**Town and Country Planning Act 1990 (As amended)
Town and Country Planning (General Permitted development) Order 2015 Schedule 2 Part 1 Class A**

Prior Notification for a Permitted Development (Householder)

Development: Notification under extended permitted development rights for a single storey rear extension measuring 4.3m from beyond the rear wall of the original dwelling house, with a maximum height of 3.55m and eaves height of 2.25m.
Location: 23 Highland Avenue Bognor Regis PO21 2BJ

LOCATION PLAN

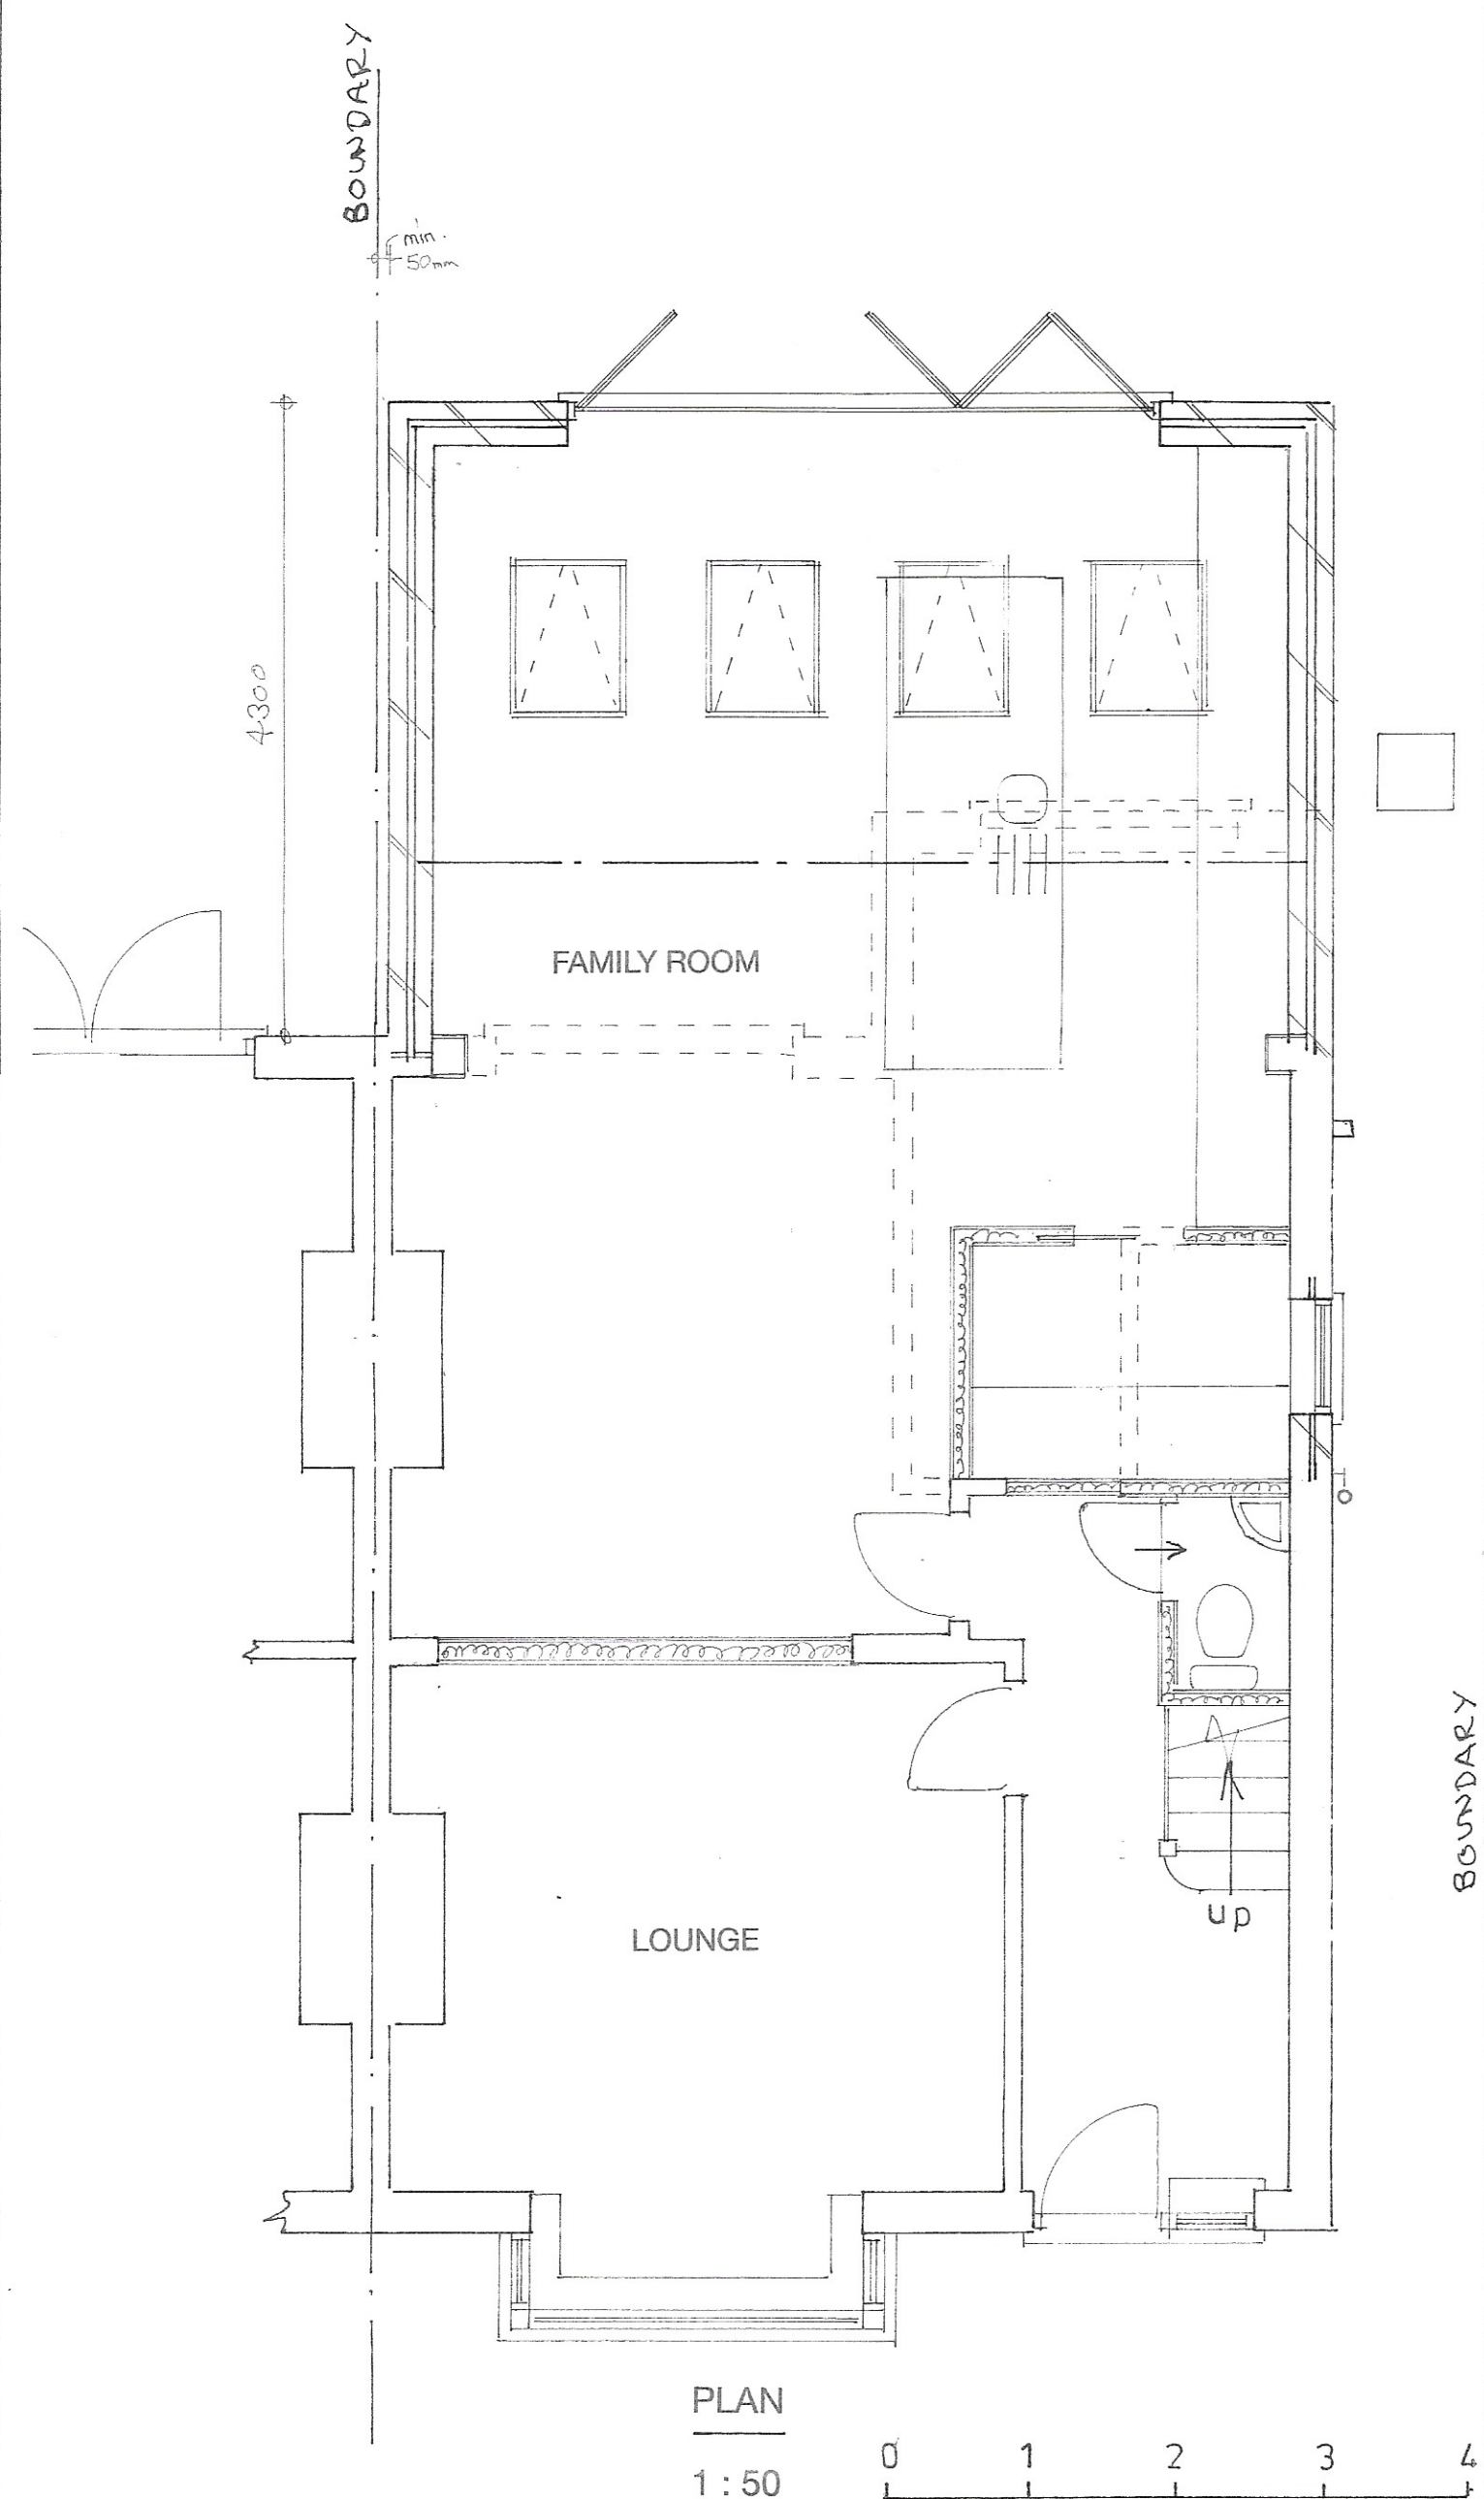
It appears your location plan has been inverted / flipped. Please amend accordingly and resubmit.
